**Western  
Sydney  
Airport**

18 November 2019

## M12 Motorway Environmental Impact Statement (SSI 9364)

Figure 1-2 Key features of the project

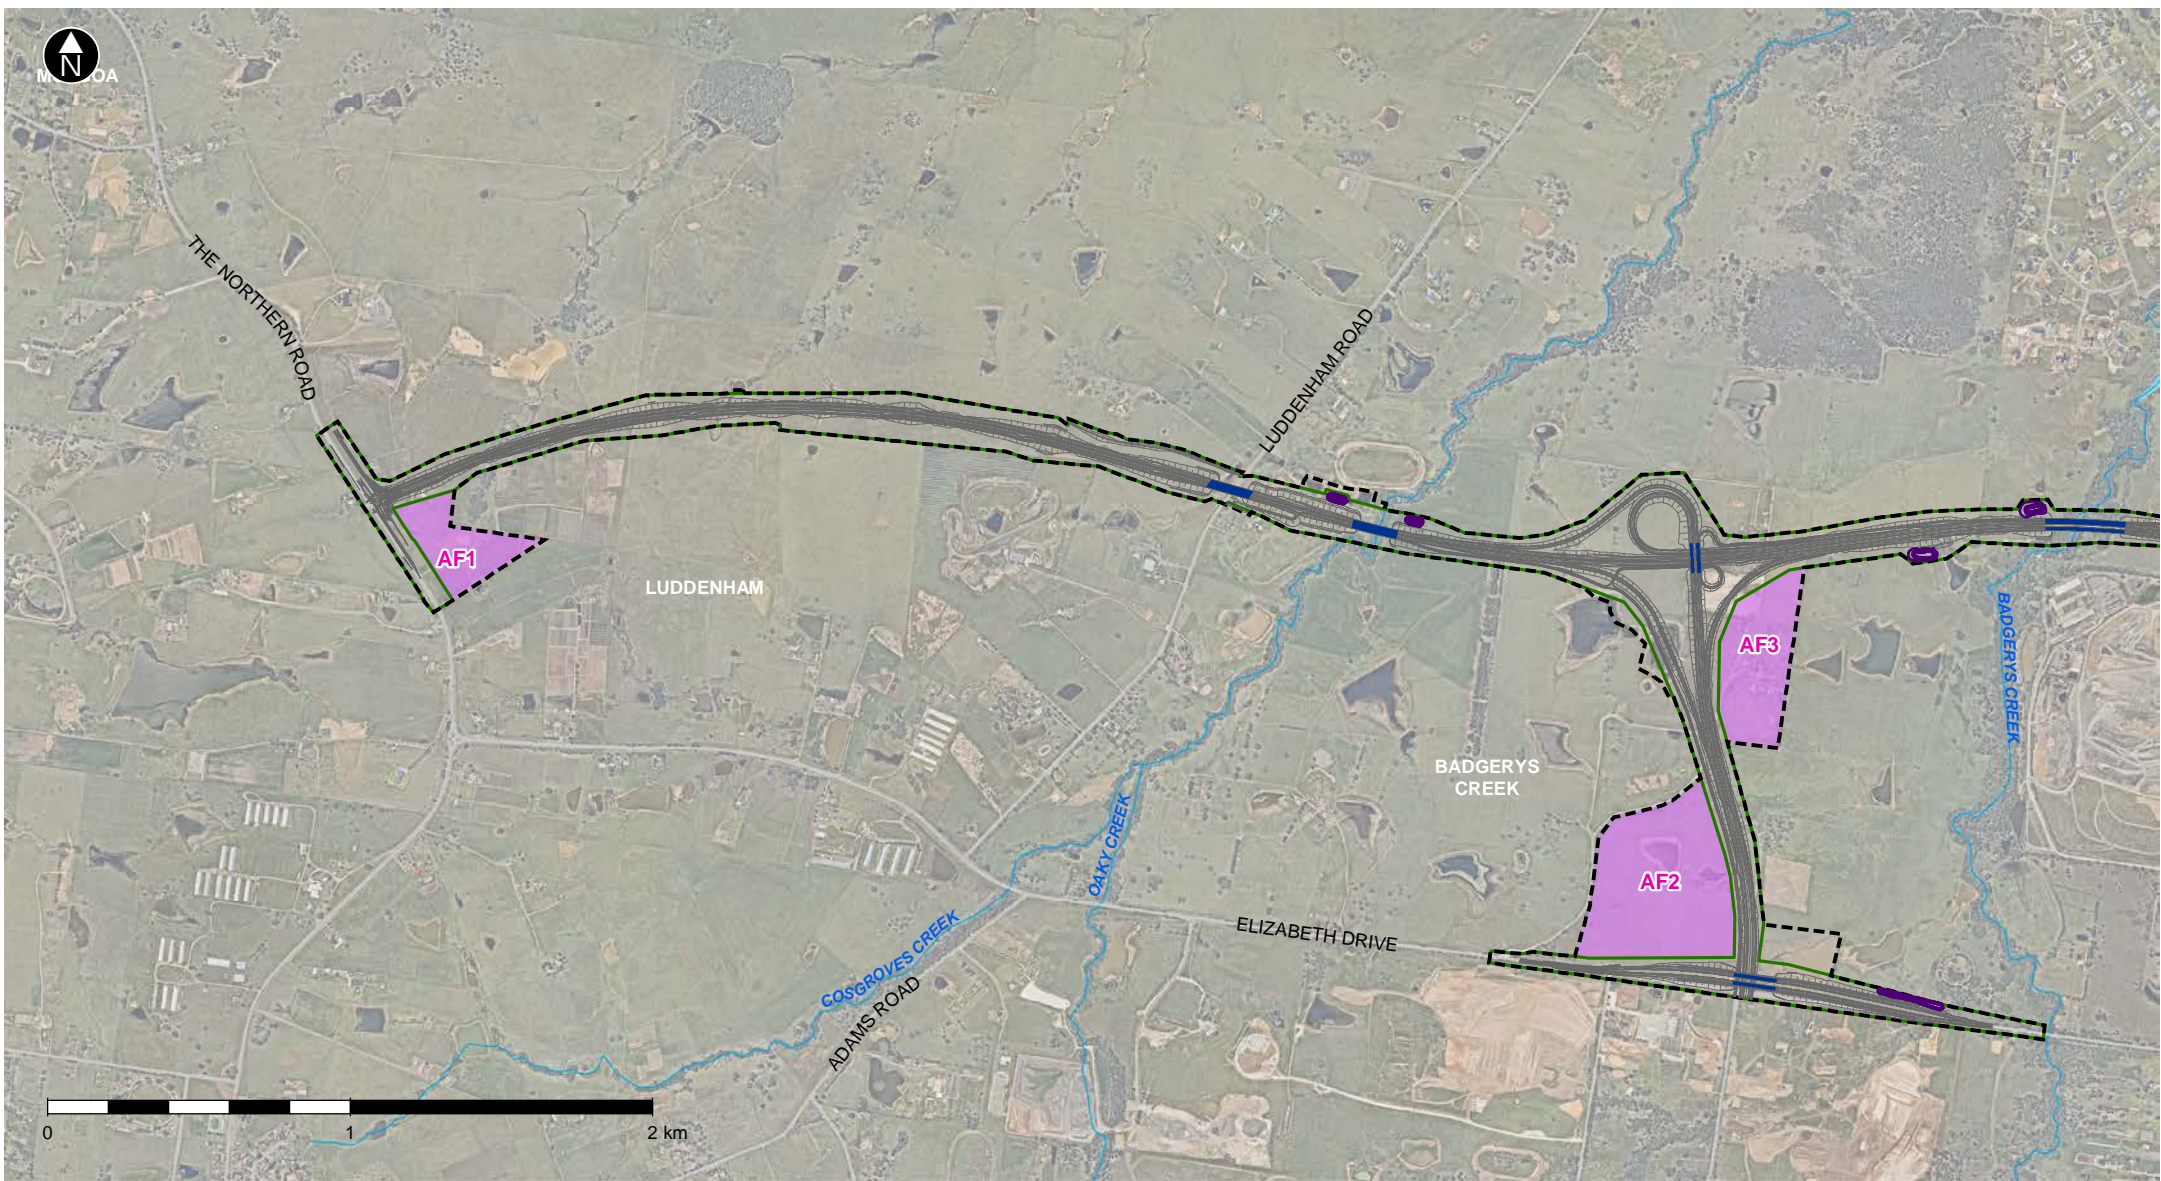
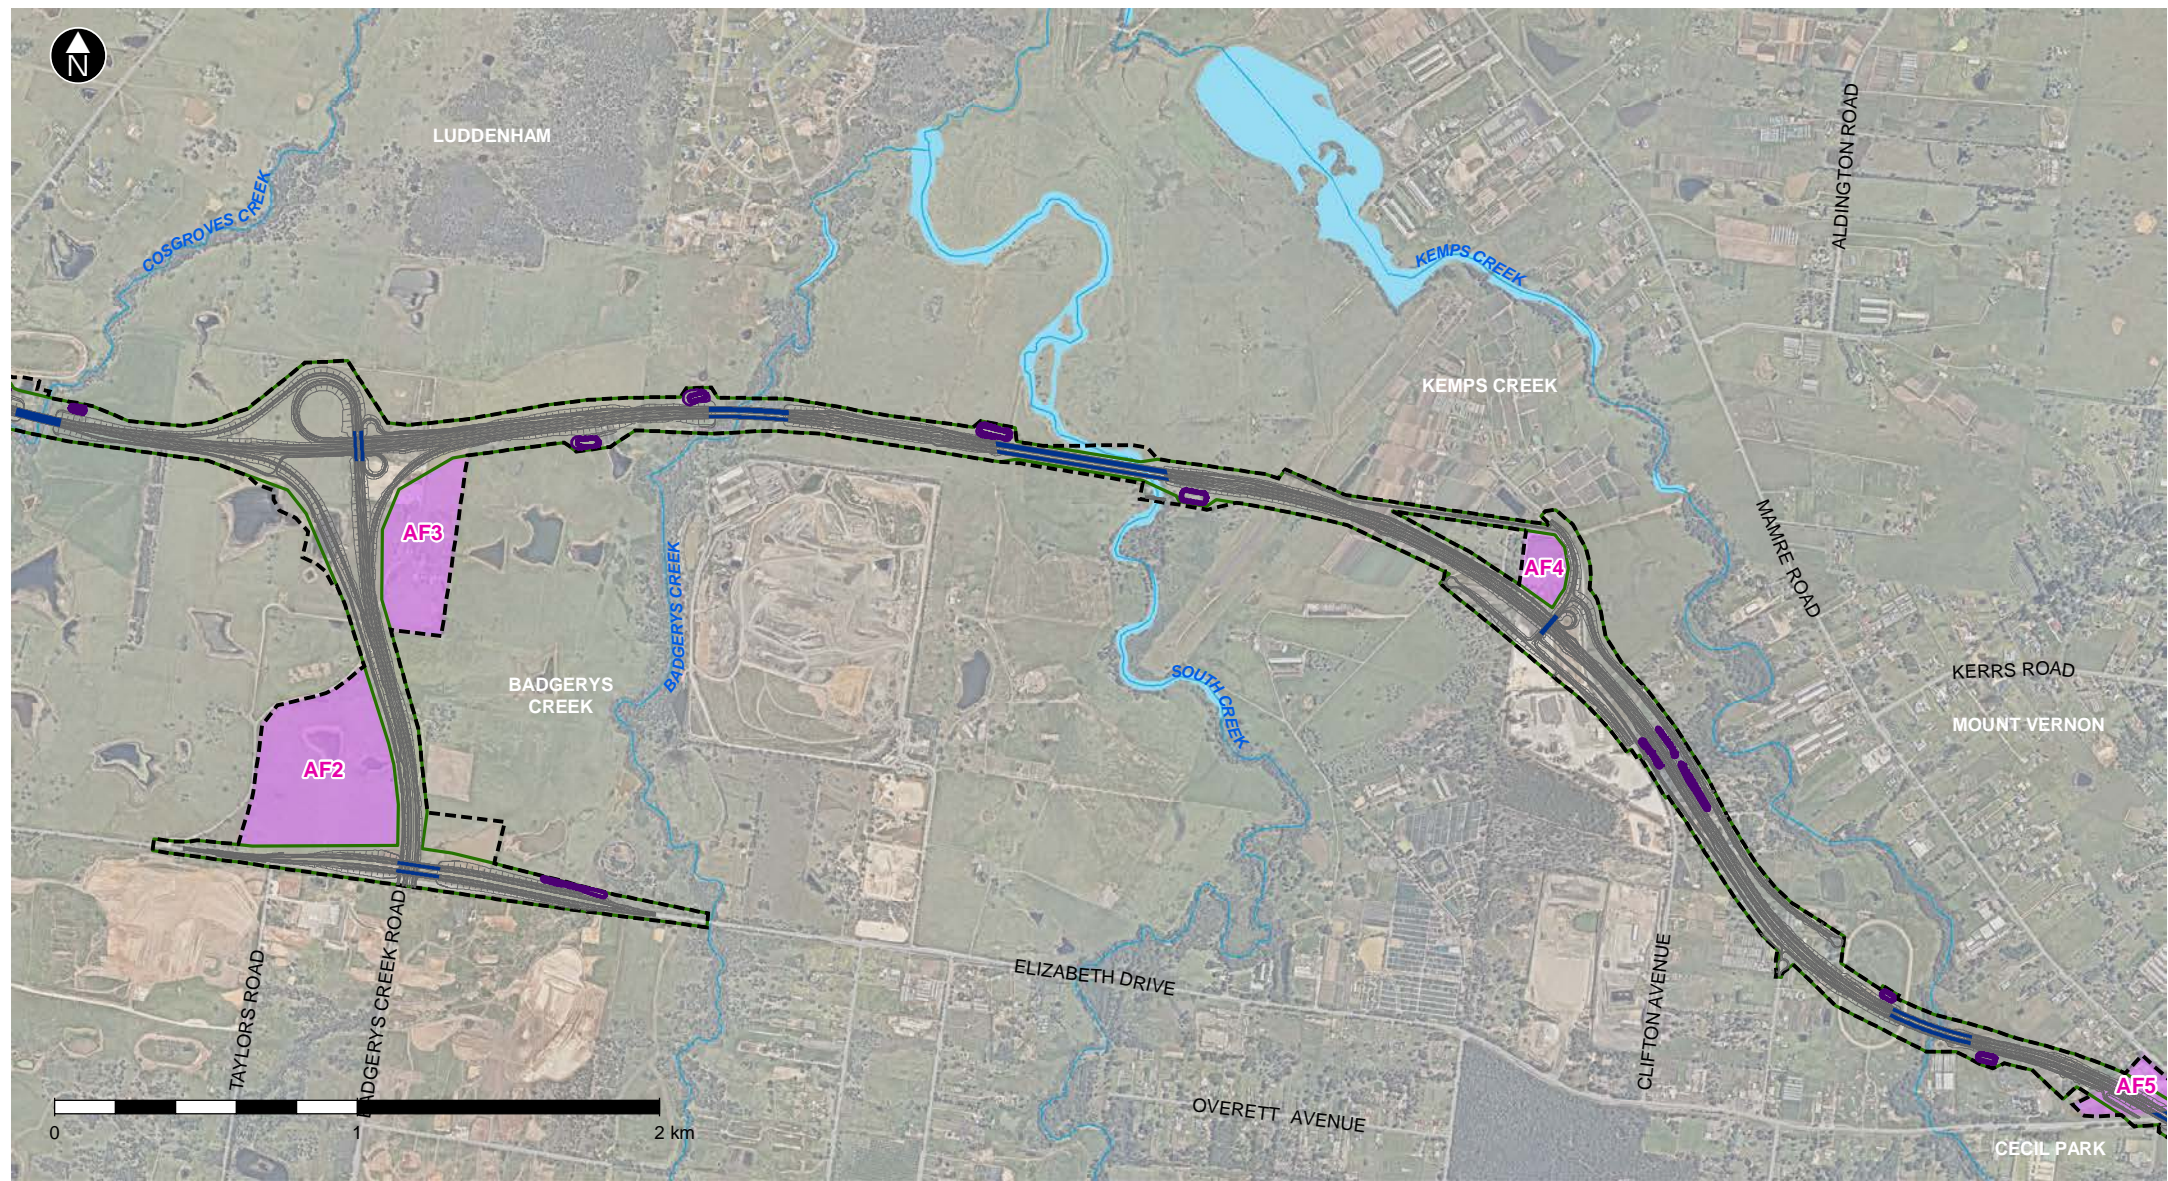
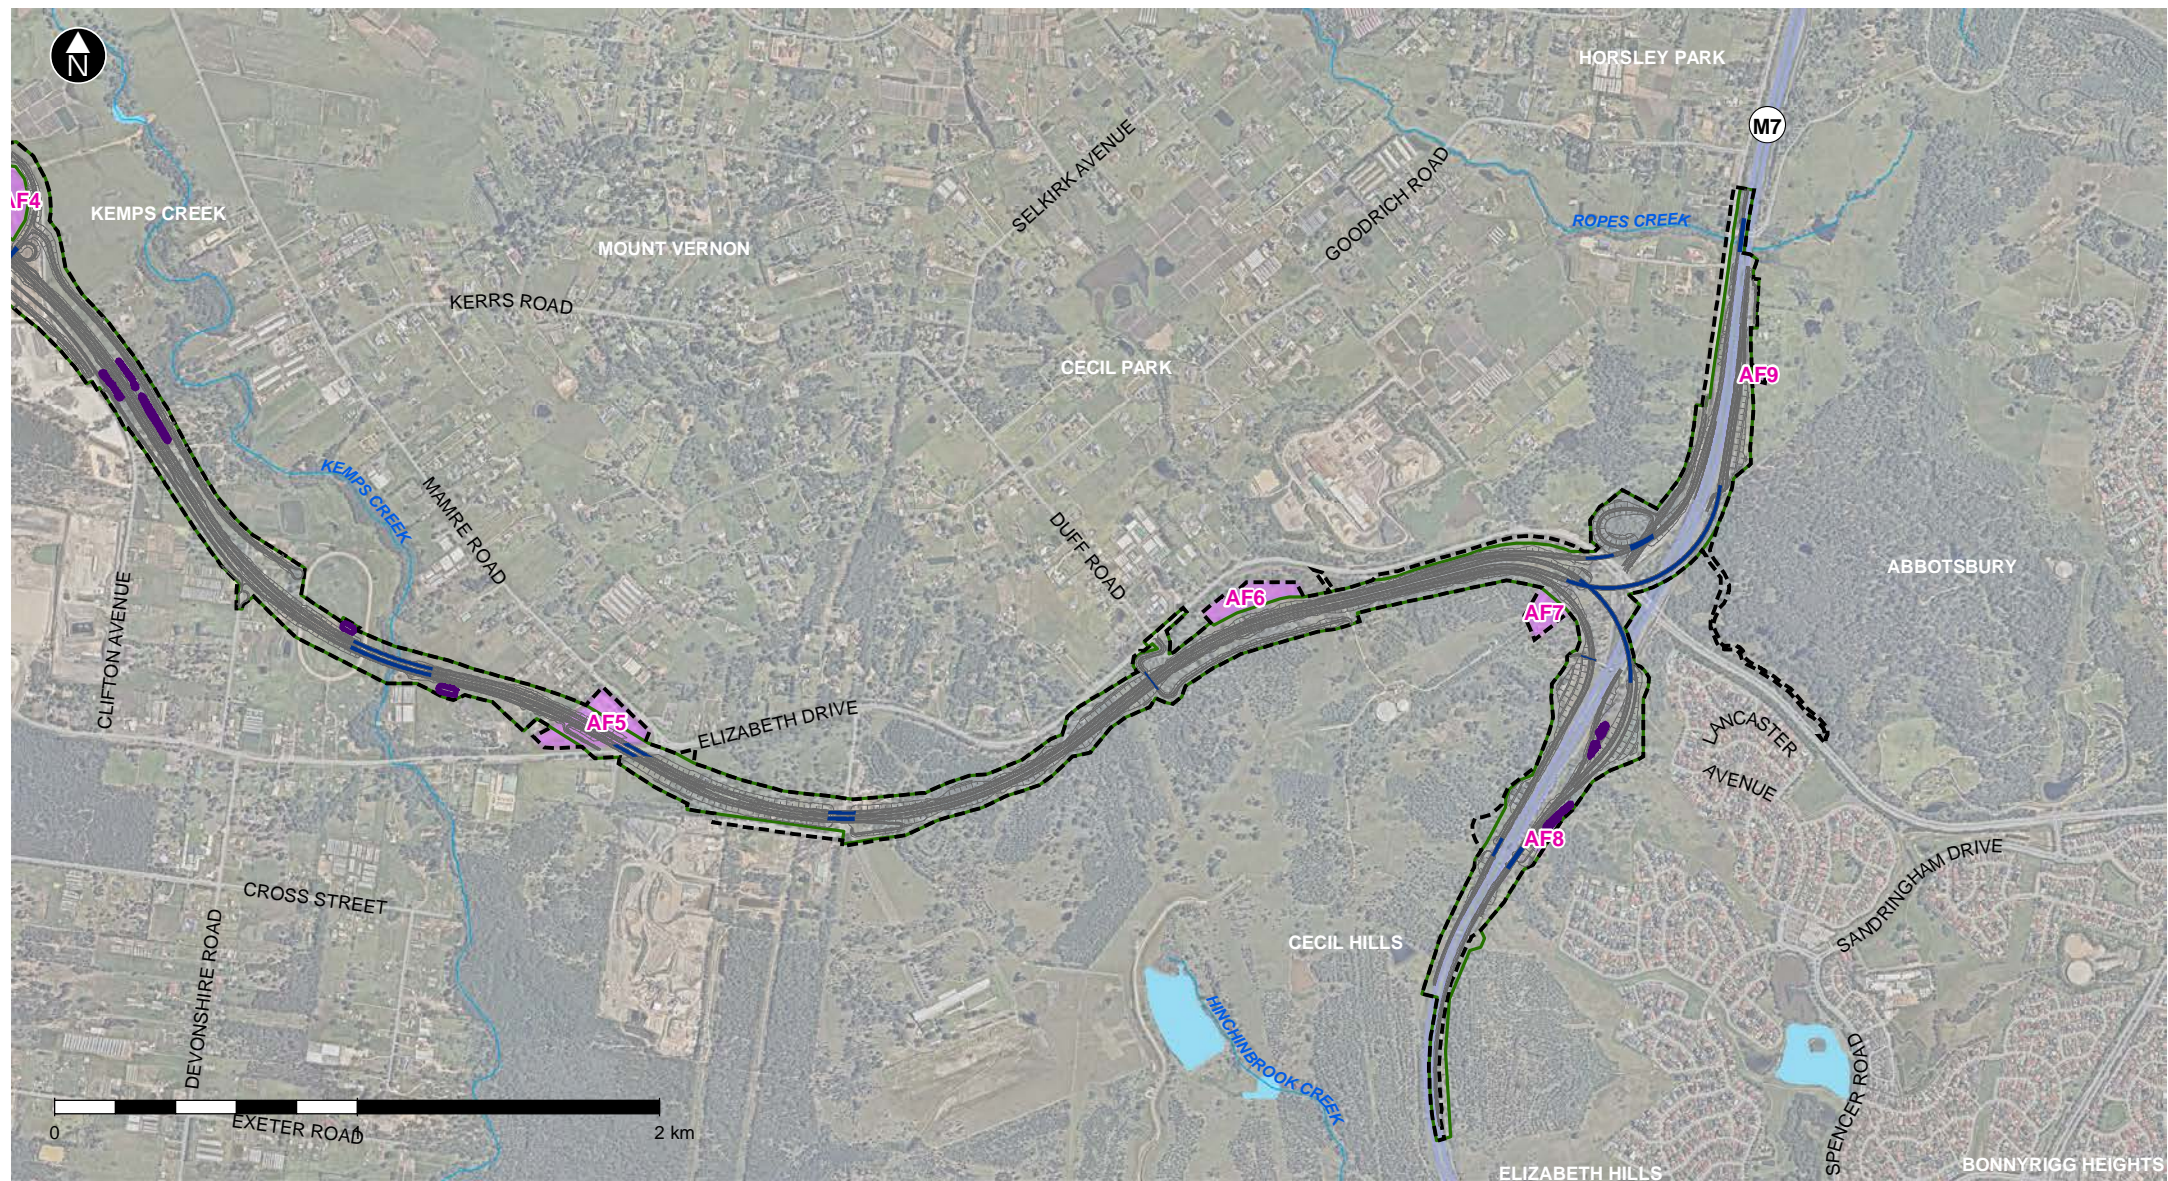
With respect to a grade-separated road interchange at the entrance to the airport, the EIS should address the design and operation of intersections at either end of the Elizabeth Drive overpass. Throughout the EIS it is indicated that the access from Elizabeth Drive is not preserved. For example, Figure 1-3 (see over) indicates that access points from Elizabeth Drive into the airport site, identified in the Commonwealth's *Western Sydney Airport – Airport Plan* (December 2016), roughly at the location of Taylors Road in the west and the realigned Badgerys Creek Road in the east, have not been appropriately considered.

The M12 design does not include on and off ramps to Elizabeth Drive at the entry to the airport site. These ramps will be important to service the development of land adjoining WSI.

WSA's suggested solution for improved connectivity at the airport entrance has been on and off-ramps to the M12 from signalised intersections at either end of the Elizabeth Drive overpass that tie into the realigned section of Badgerys Creek Road in the east and/or to the secondary airport access road to the west. However, there are many options that deliver some or all of the necessary connectivity that should be evaluated as part of the EIS.
